# ENG-PUDSP21005-R3-PUDSP.pdf Markup Summary

**Subject:** Callout  
**Page Index:** 1  
**Date:** 4/15/2022 3:10:03 PM  
**Author:** Ryan Howser  
**Color:** ■  
**Layer:**  
**Space:**  
**Page Label:** [1] WB PUDSP 3.10.22-Cover

SHEET TITLE:  
**TRACTS  
PLAN**

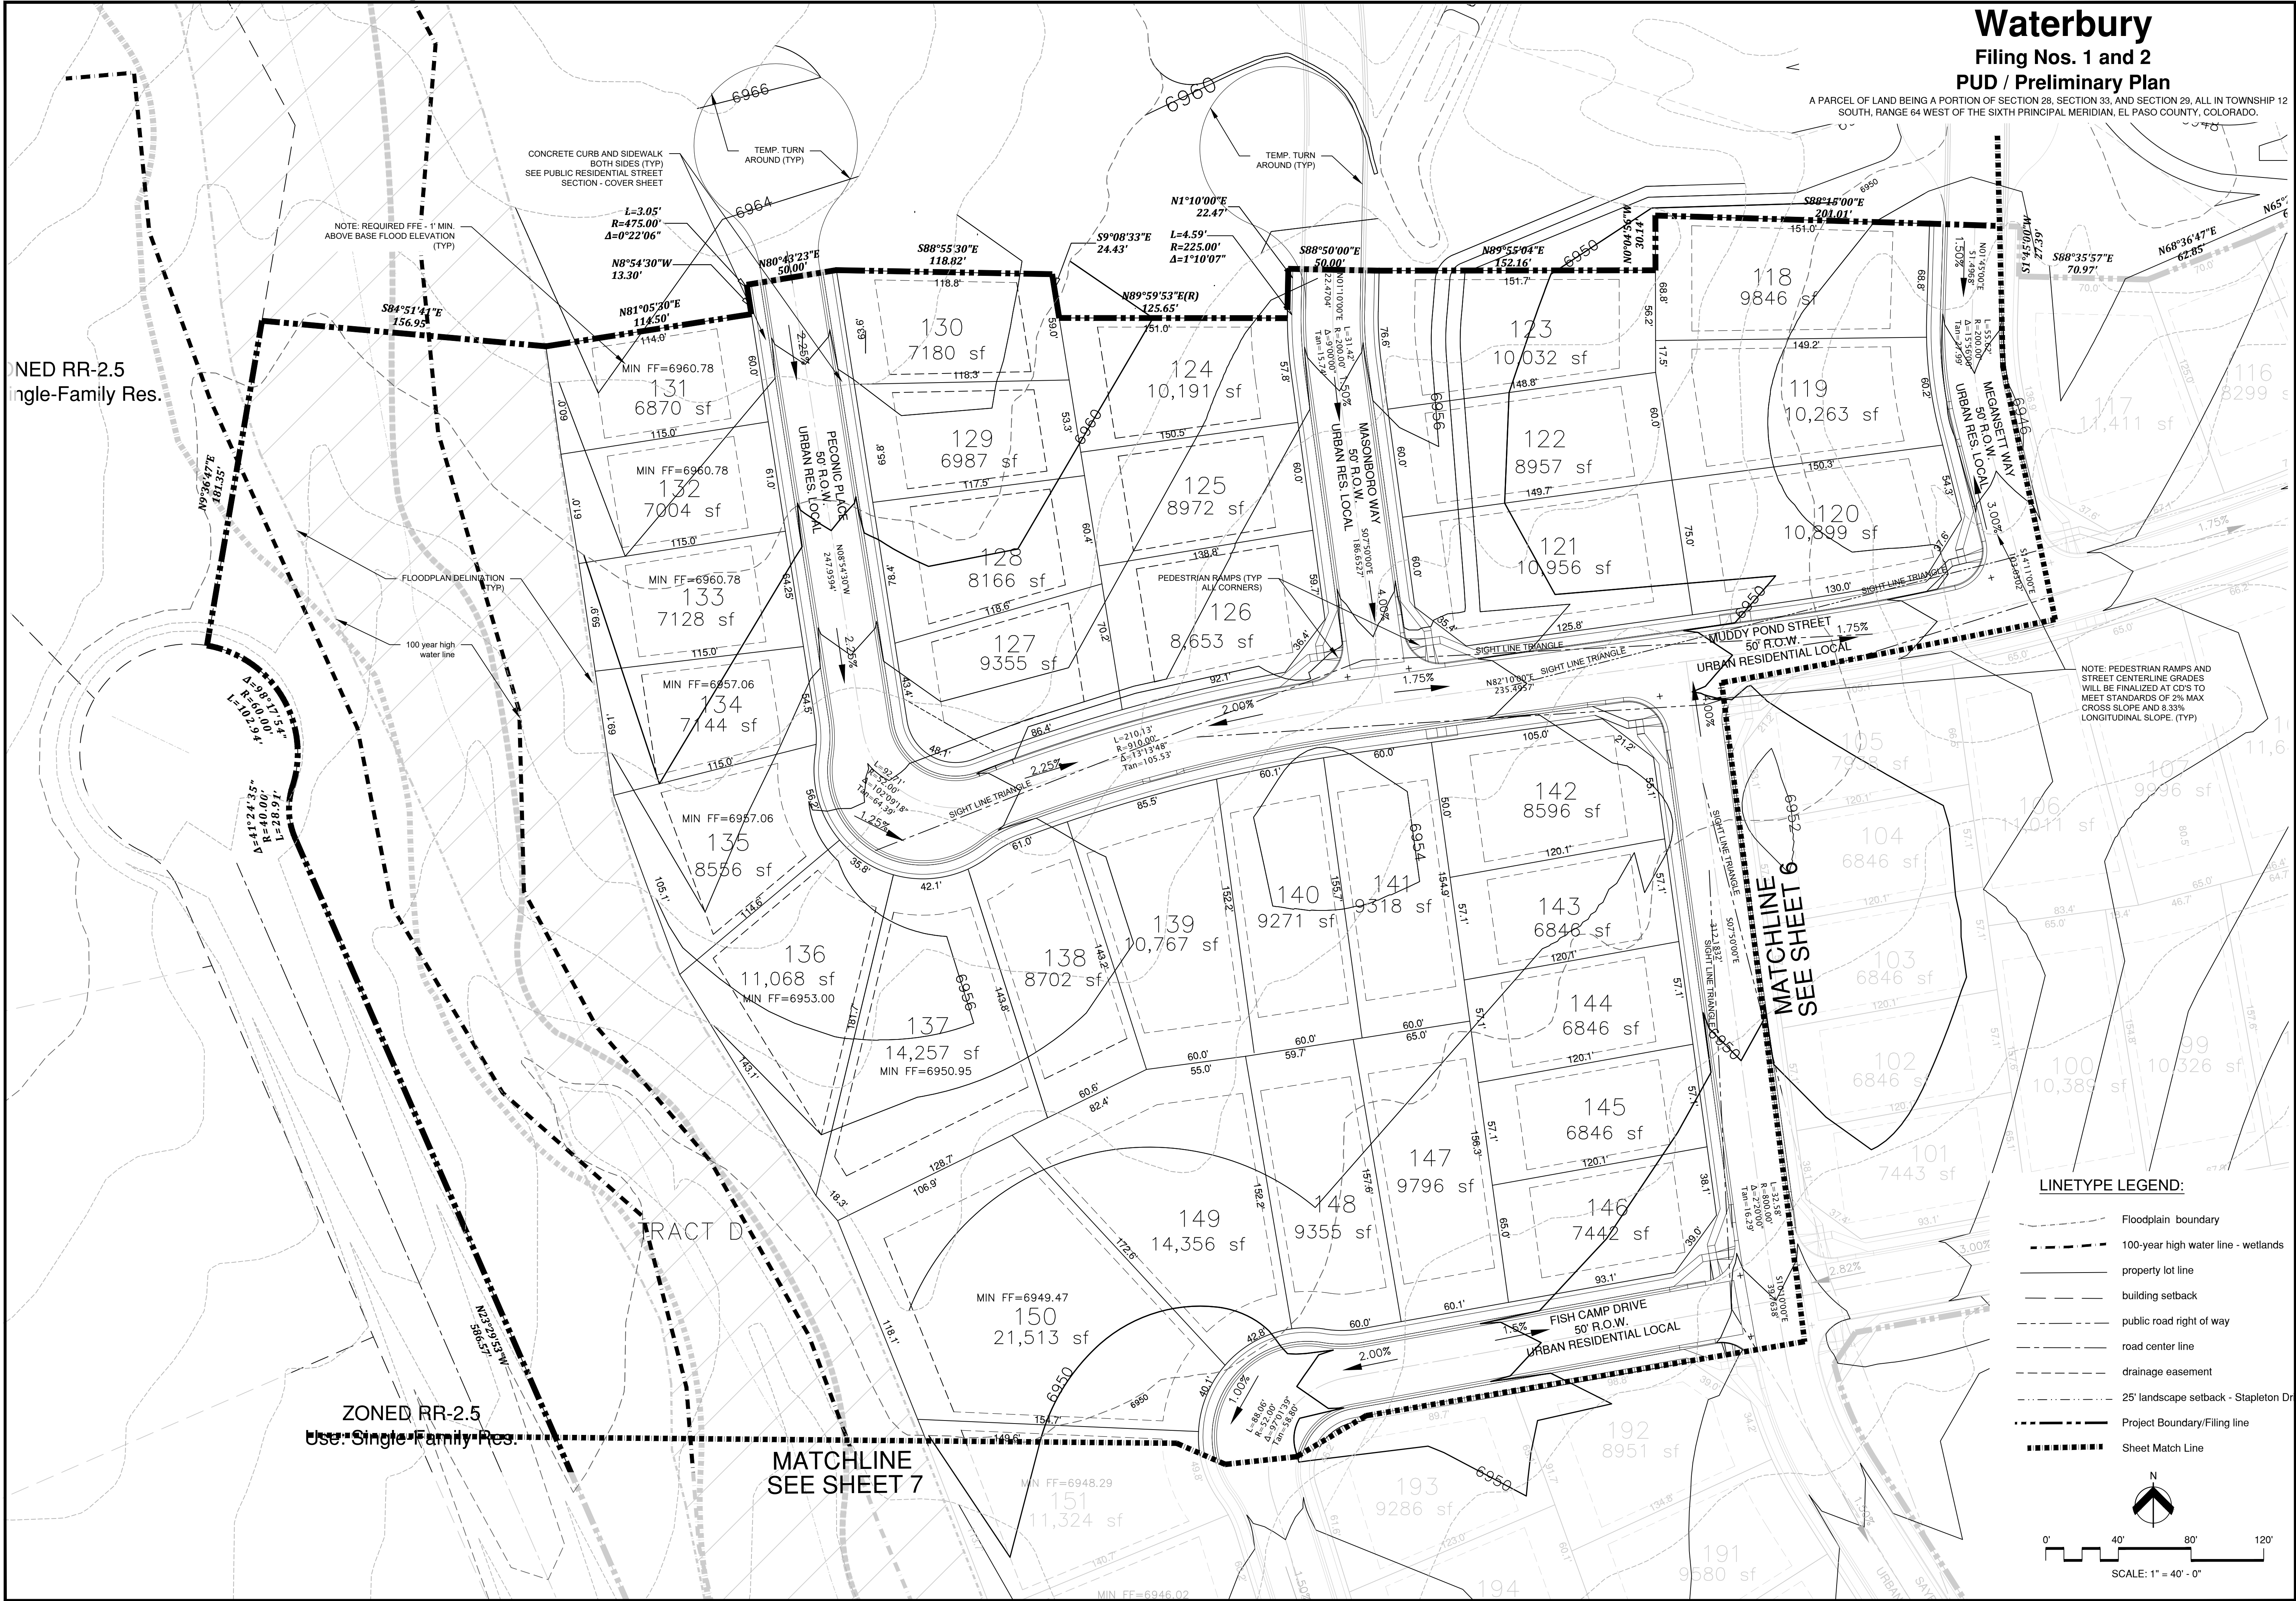
Show delineation between 2 drainage easements called out

please turn off the text box outlines

corrected

corrected

SHEET TITLE:  
**NORTHWEST AREA DEVELOPMENT PLAN**

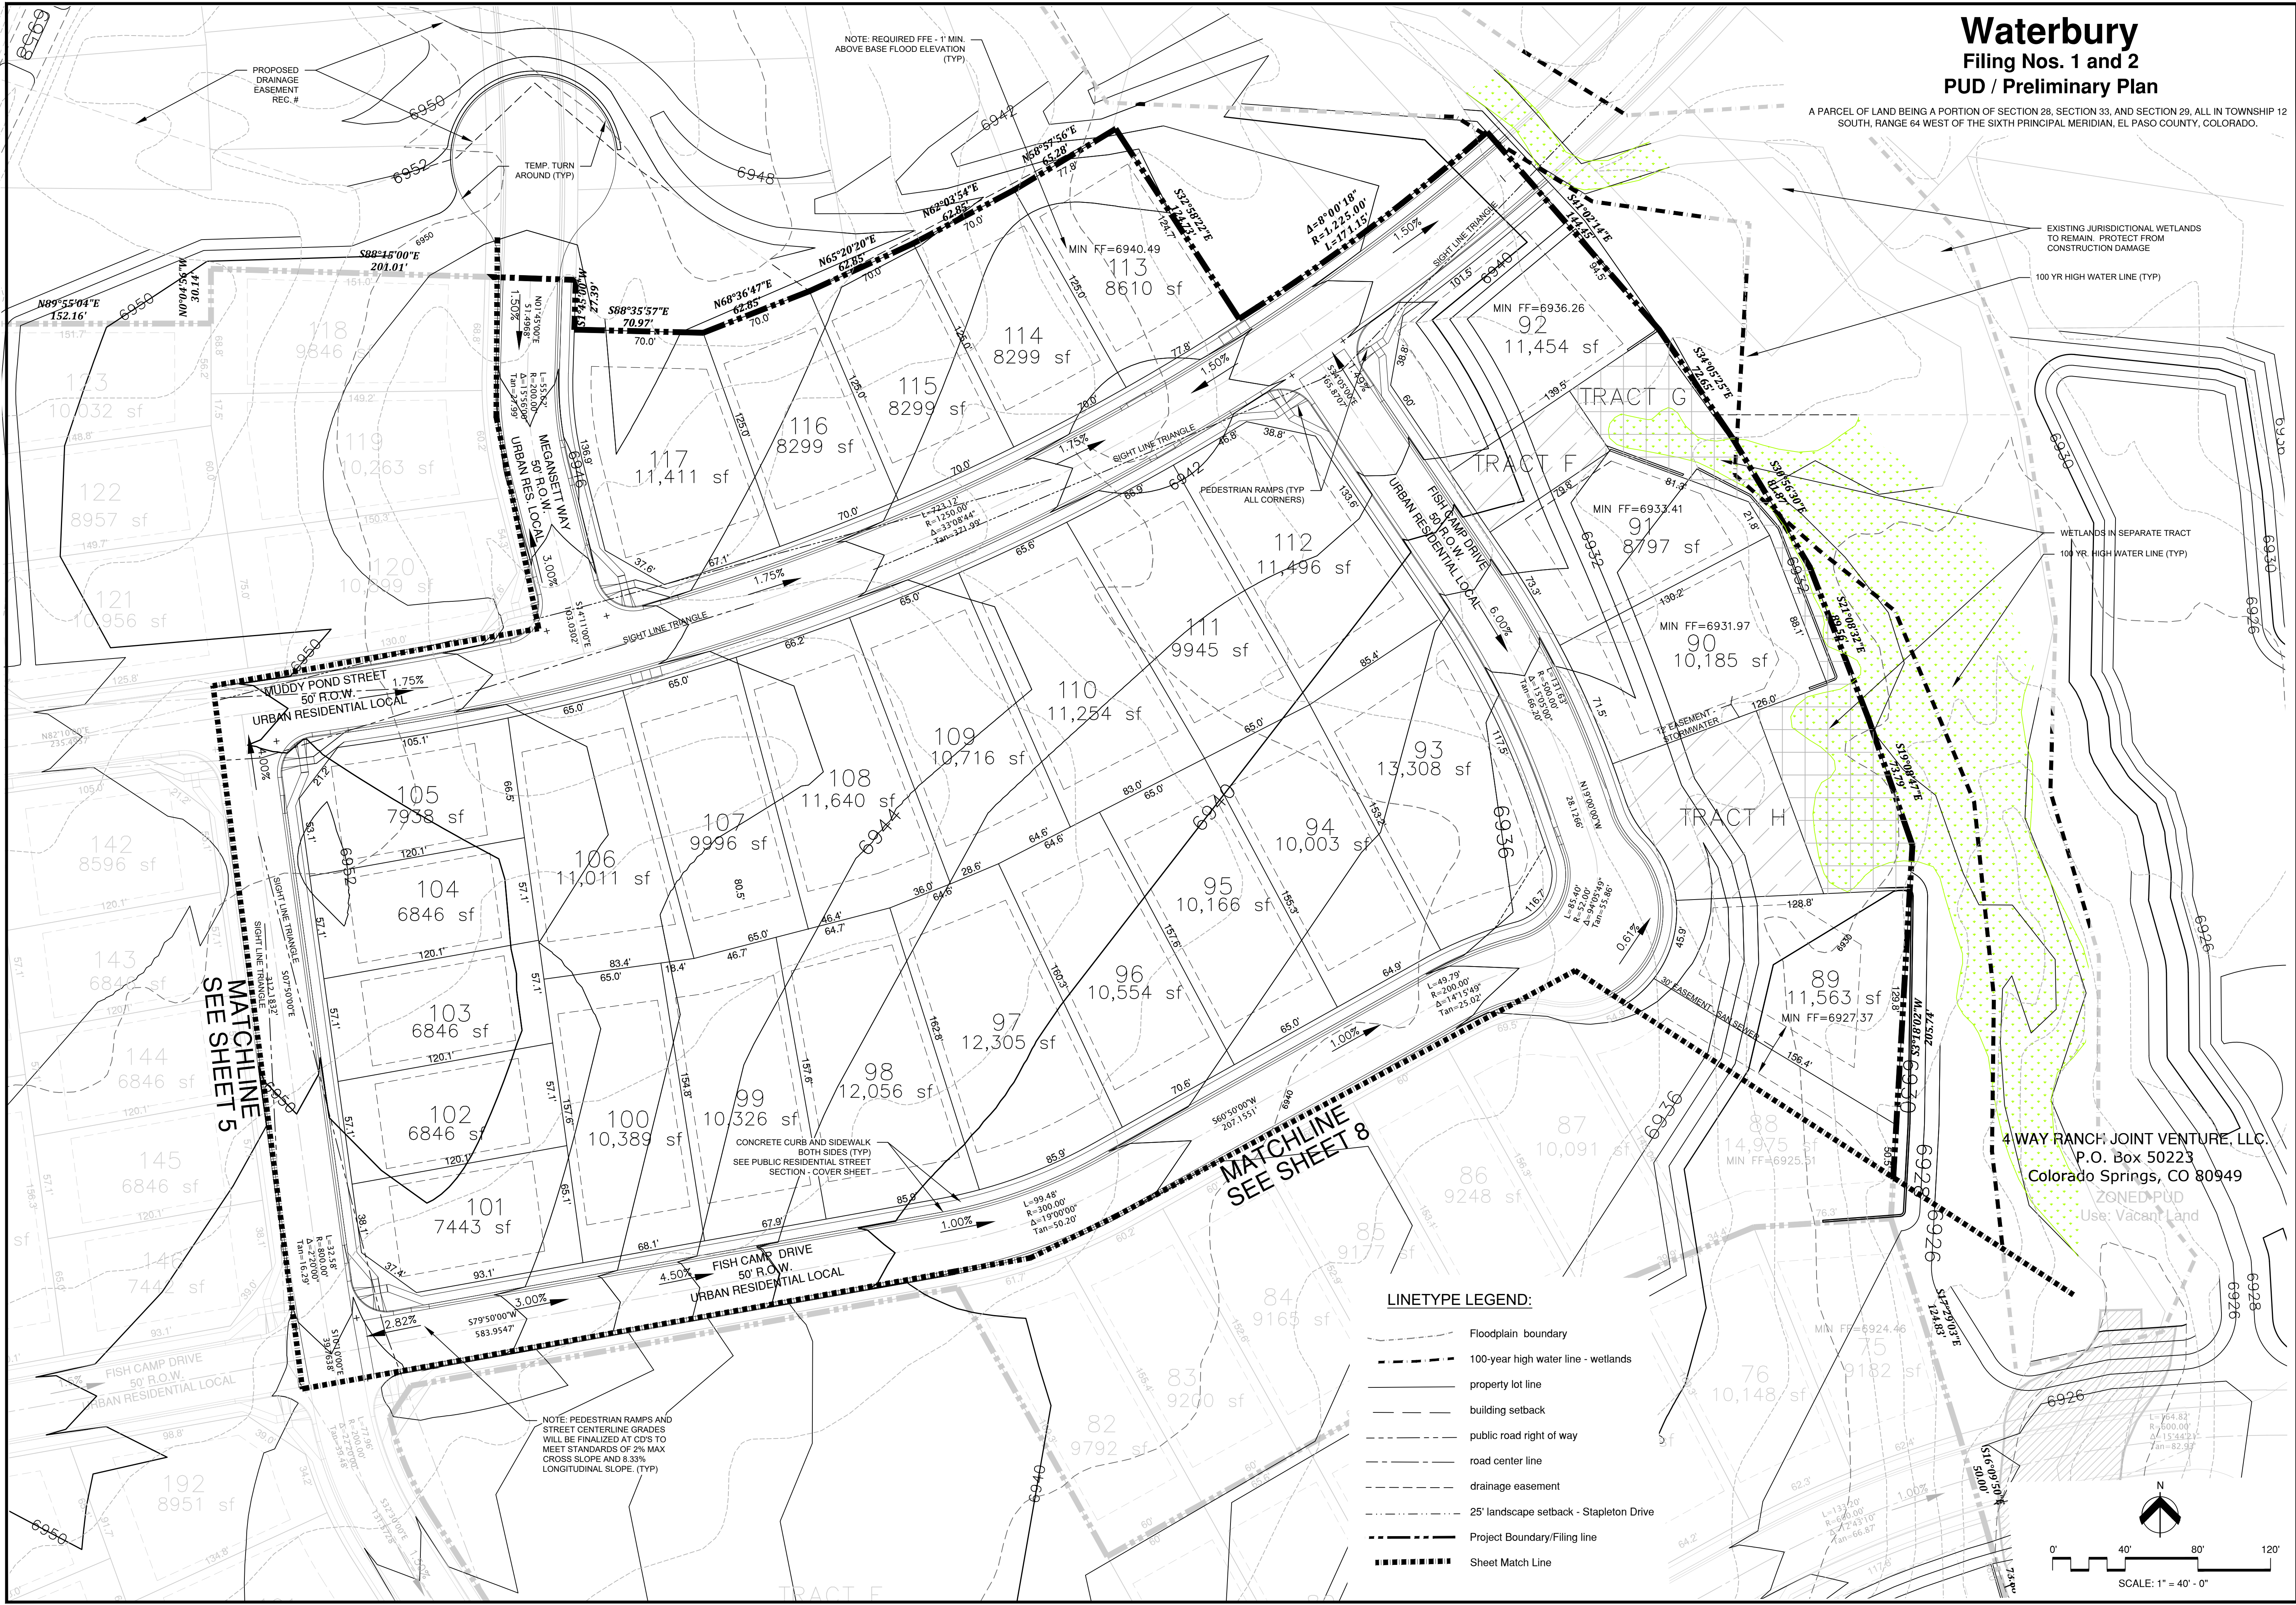
Label sight line triangle line

These grades and others highlighted on this sheet are higher than allowed for ADA crossings. Ensure that the pedestrian crossing cross-slopes will meet criteria.

added

note added to all relevant sheets that Final Grades (spot grades) will be adjusted on CD's as needed to meet ADA requirements

SHEET TITLE: NORTHEAST AREA DEVELOPMENT PLAN

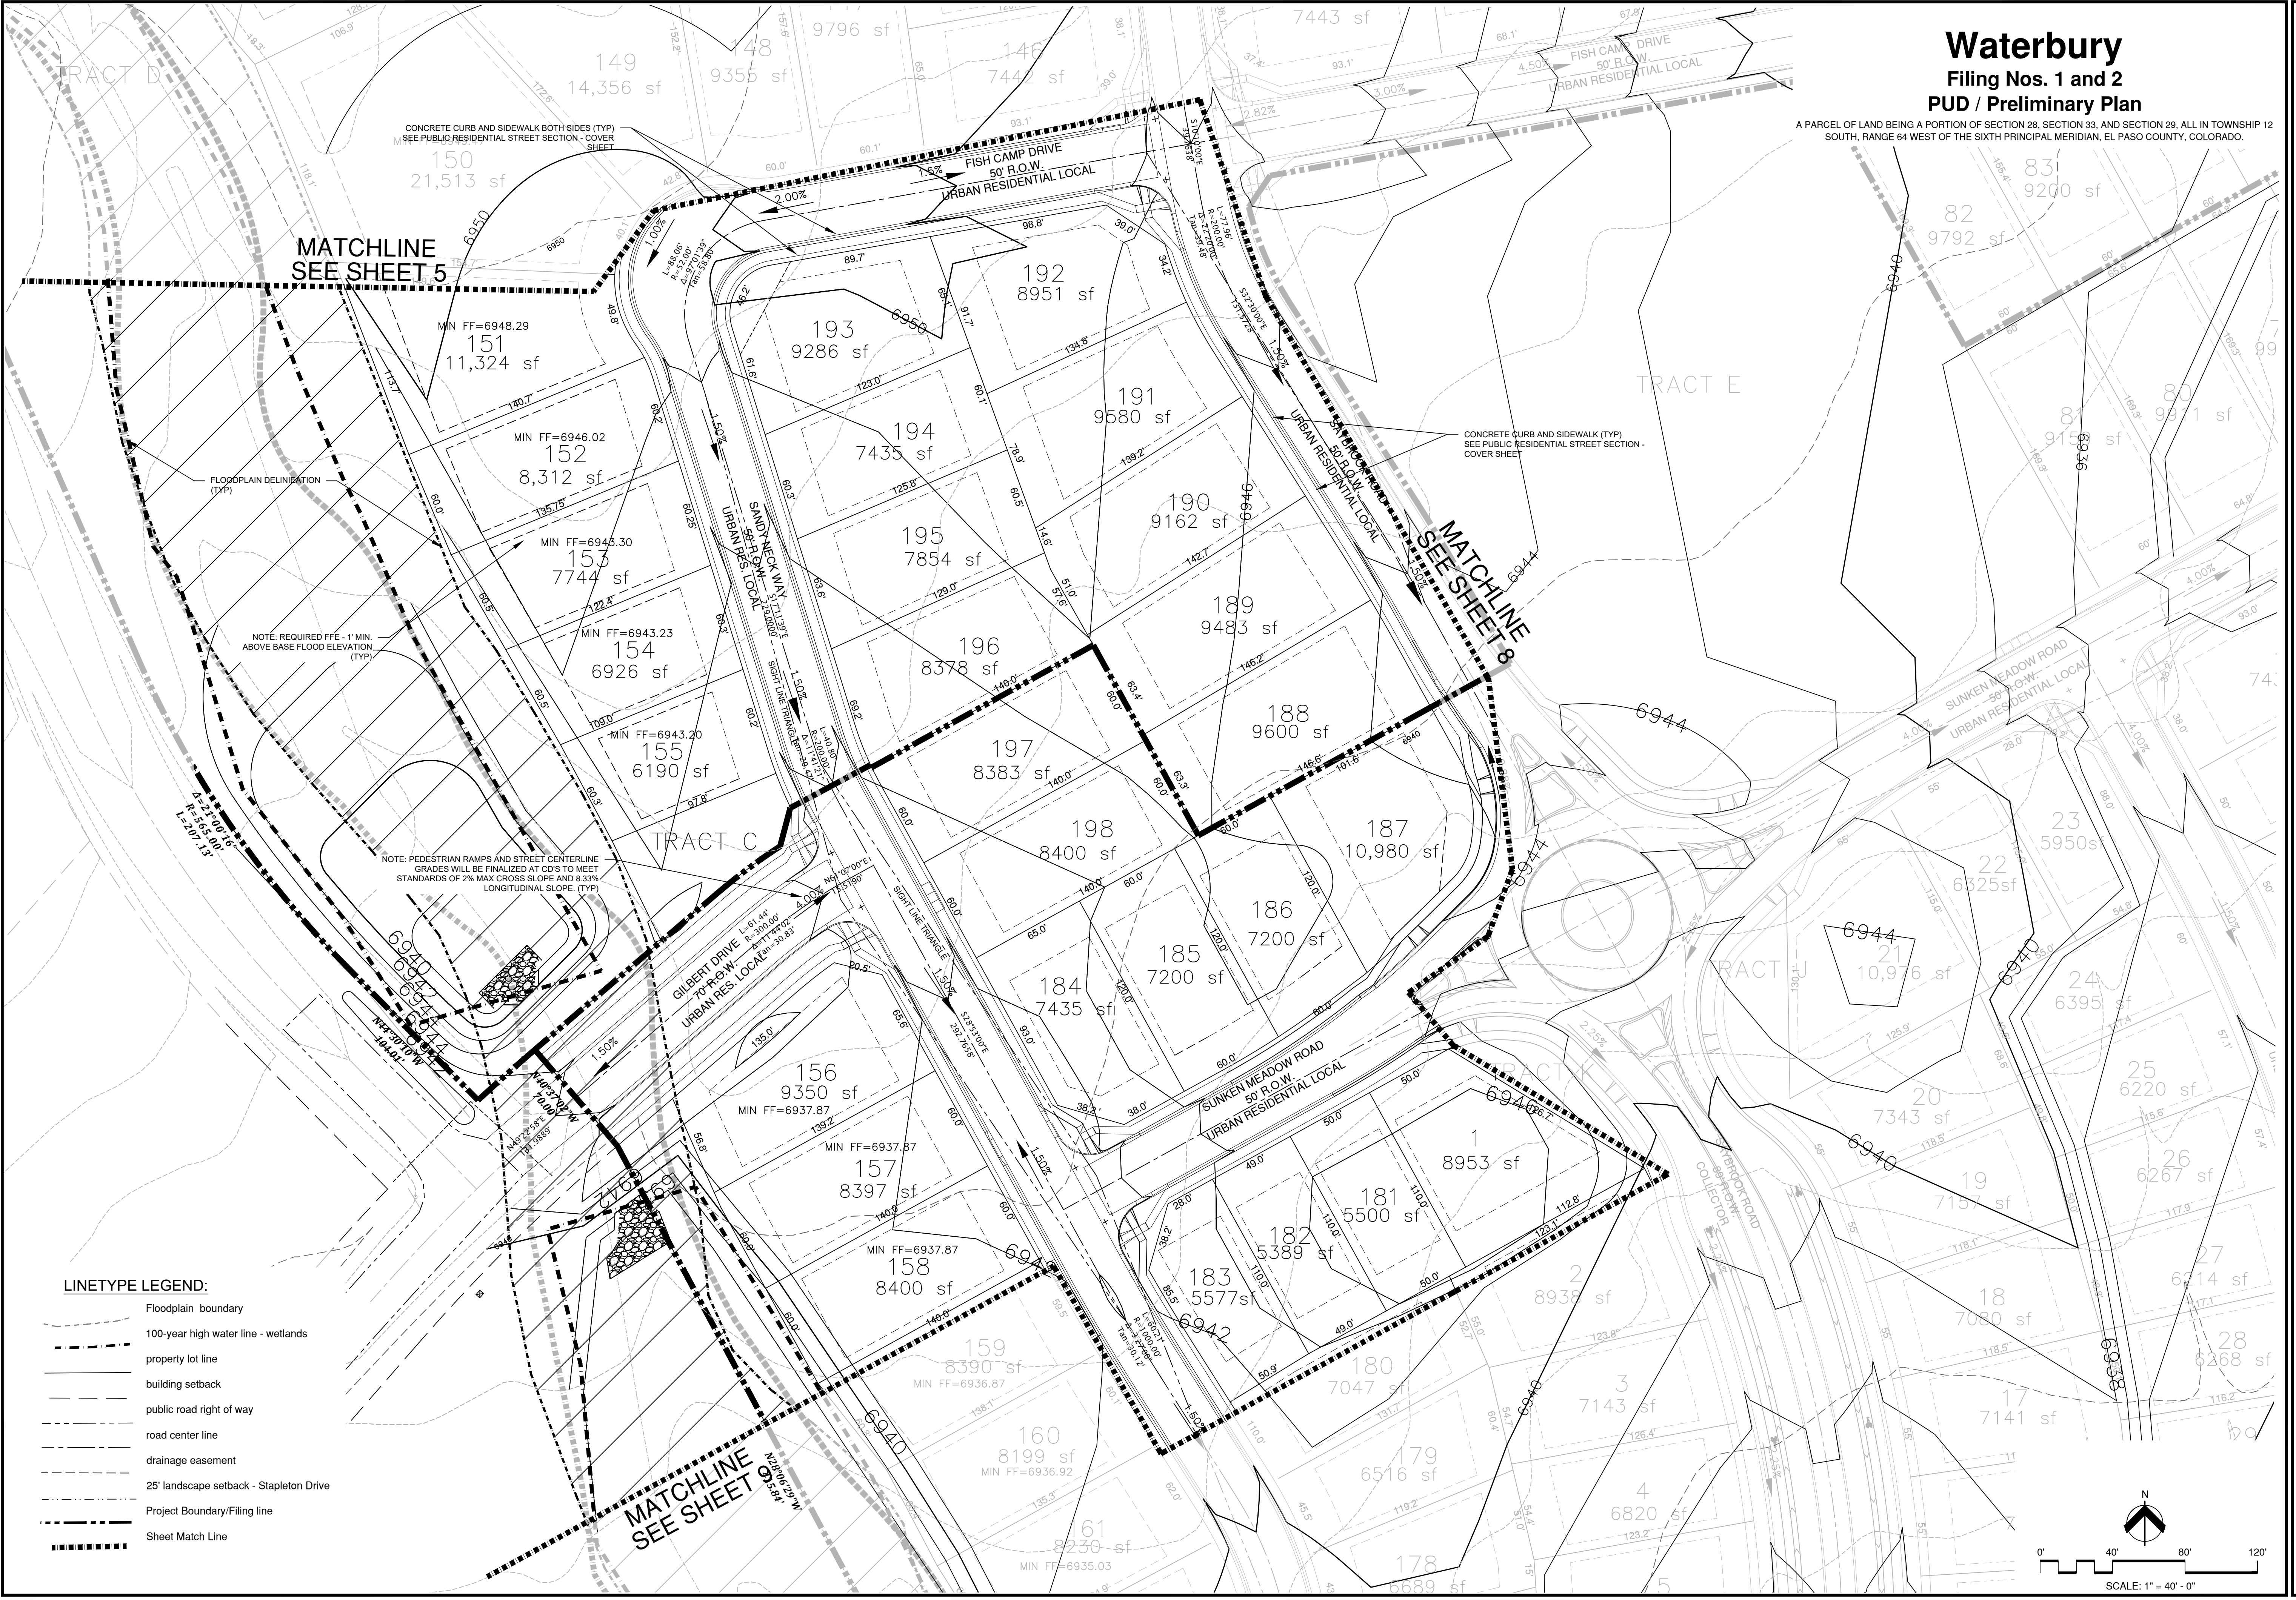
Missing sight line

Label sight line triangles

Extend line to ROW

added

added

corrected
